Ribble Valley Borough Council
Housing & Development Control

Application no: **3/2020/0546**

Address: **Barn at Horton Grange Farm Horton Skipton BD23 3JT**

Proposal: **Change of use of existing agricultural building into one dwelling and associated operational development under class Q (a) and (b).**

- 1. Existing agricultural storage
- 2. Proposed barn conversion
- 3. Proposed residential access
- 4. Proposed garden
- 5. Proposed parking
- 6. Proposed bin store
- 7. Proposed planting
- 8. Proposed agricultural access
- 9. Existing planted buffer
- 10. Neighbouring building

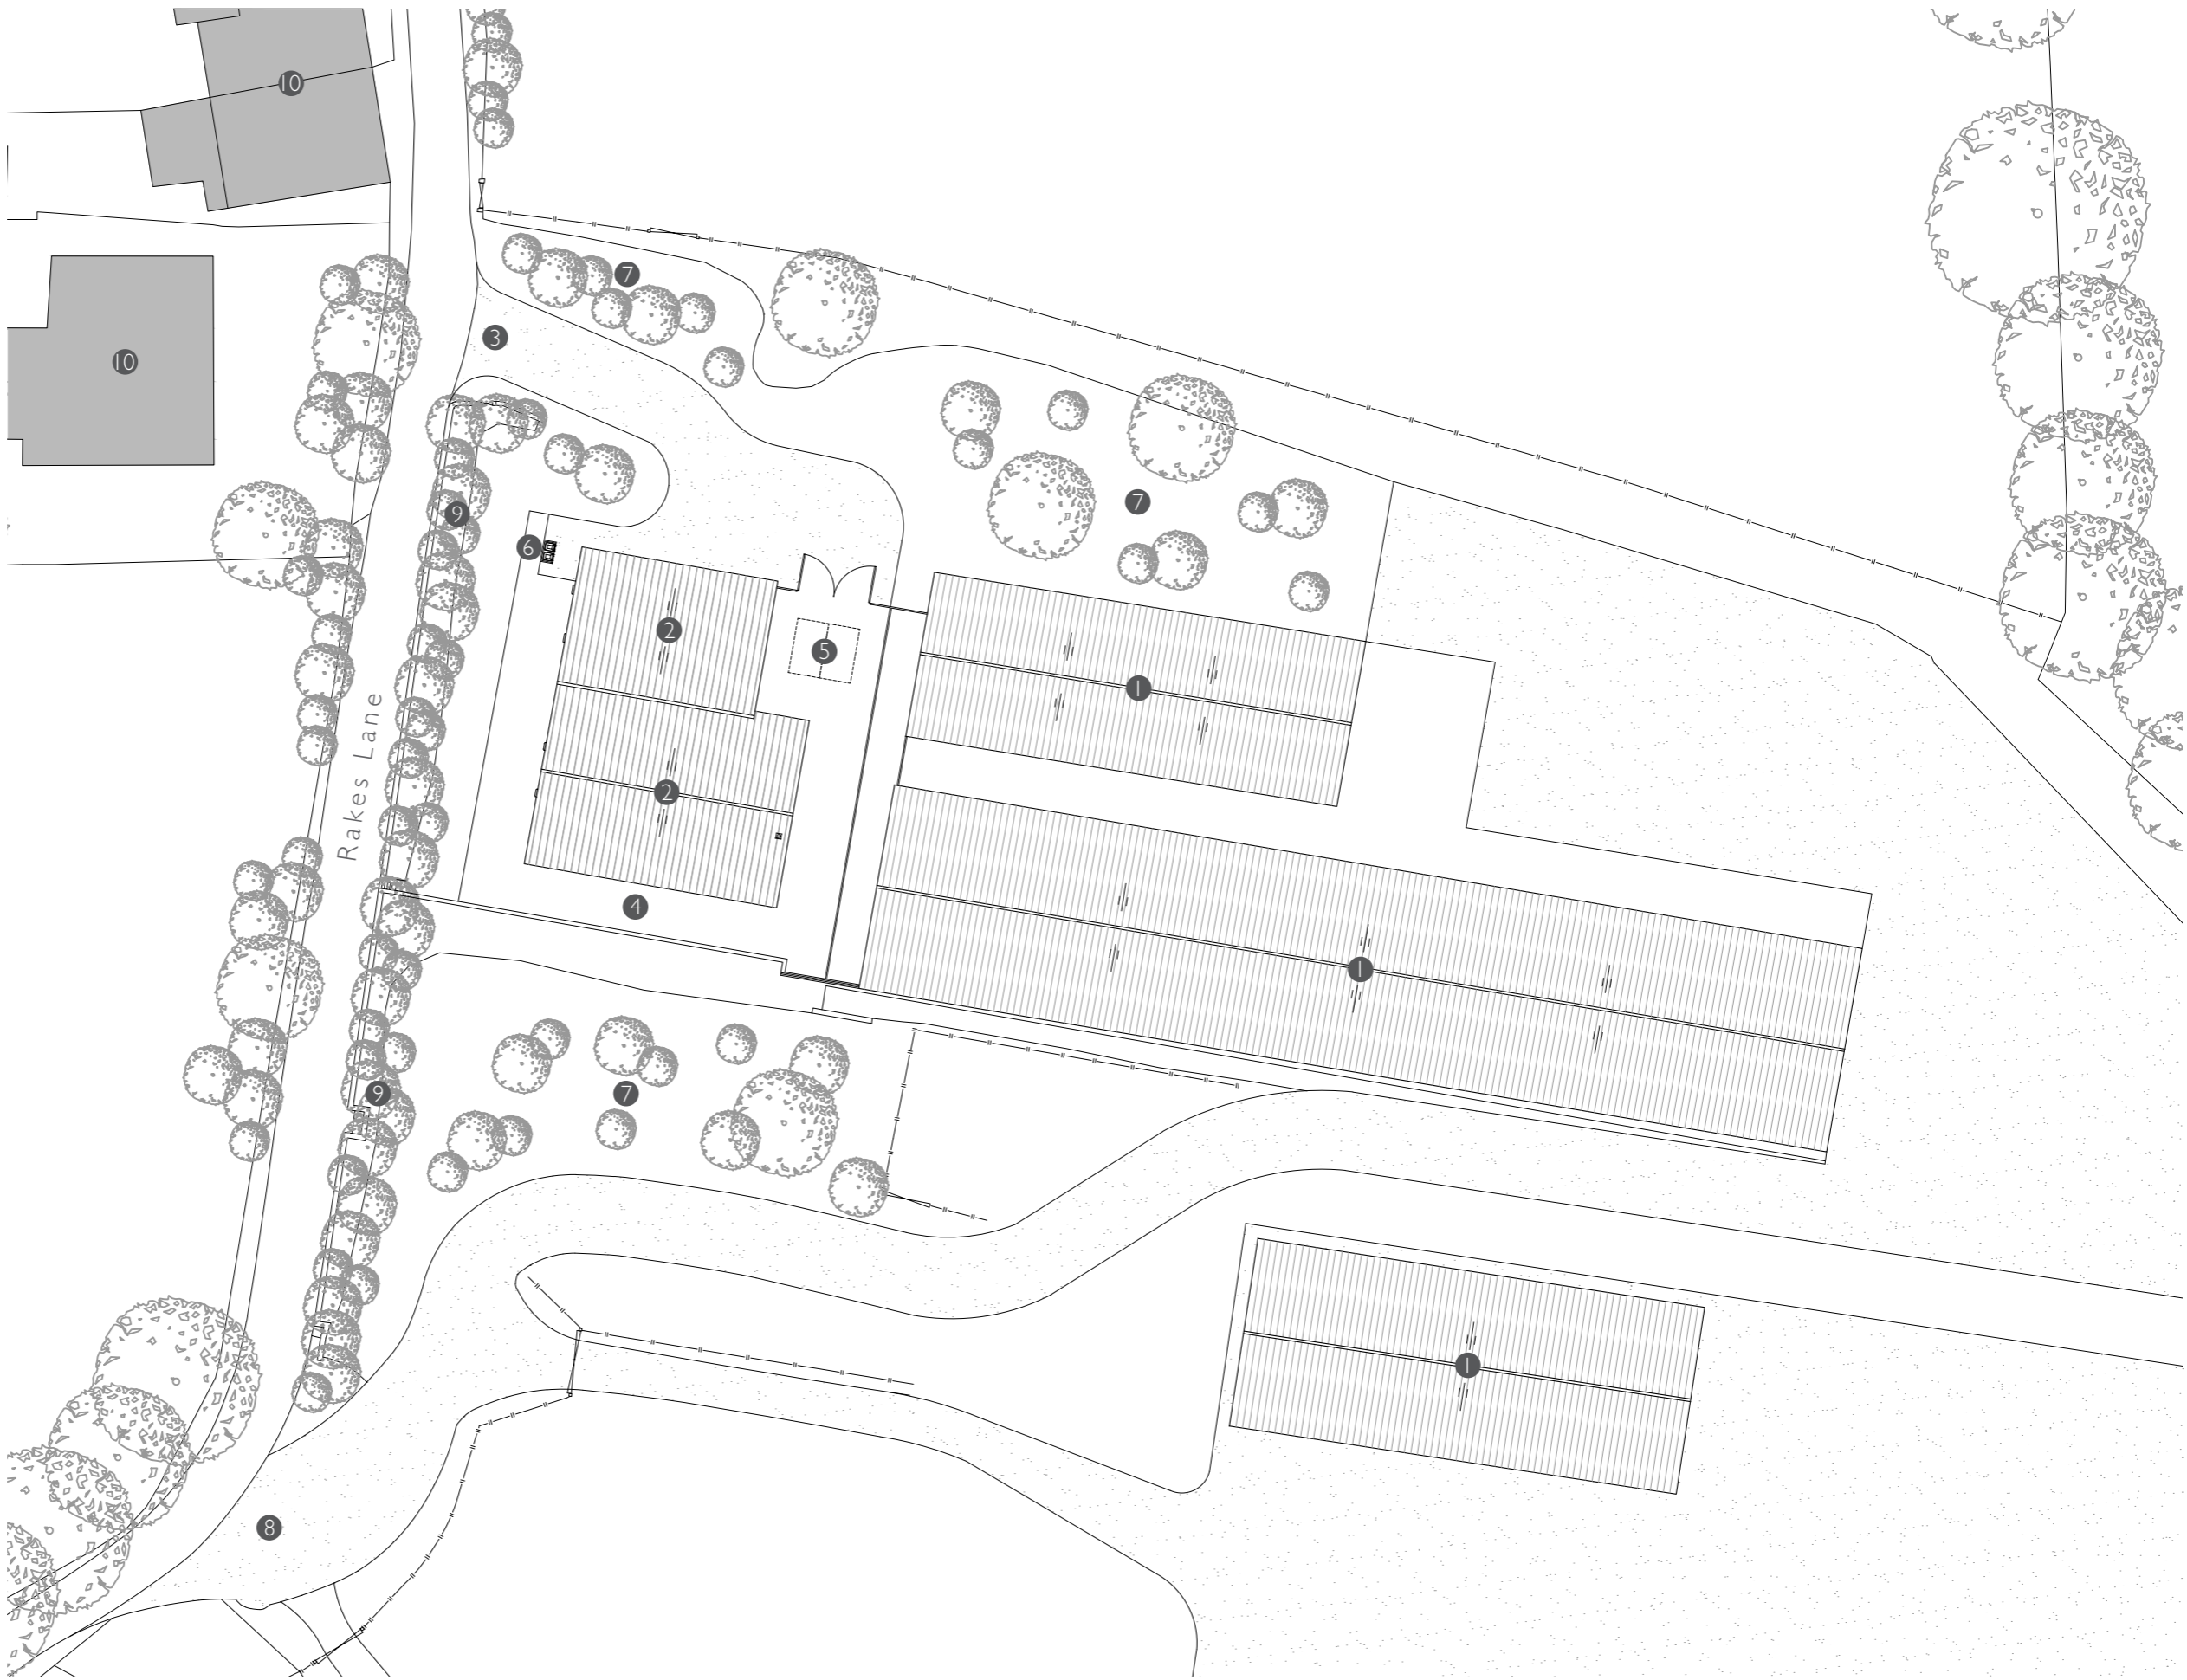
The proposed change of use under class Q (a) and (b) will involve the conversion of barns to a single residential dwelling, which in turn will fall under class C3. The northern entrance to the existing farmyard will only be used as access to the proposed dwelling and therefore the Local Highway Authority would require the first 5m of this access point, leading to the public highway, to be bound with an approved surface material as well as the visibility splays being maintained at a height no greater than 1.05m above road level in perpetuity of the development

1. Notwithstanding the provisions of the Town and Country Planning (General Permitted Development) Order 1995 there shall not at any time in connection with the development hereby permitted be erected or planted or allowed to remain upon the land hereinafter defined any building, wall, fence, hedges, trees, shrubs or other devices over 1.05m above road level.

2. Before the access is used for vehicular purposes, that part of the access extending from the highway boundary for a minimum distance of 5m into the site shall be appropriately paved in tarmacadam, concrete, block pavements, or other approved materials.
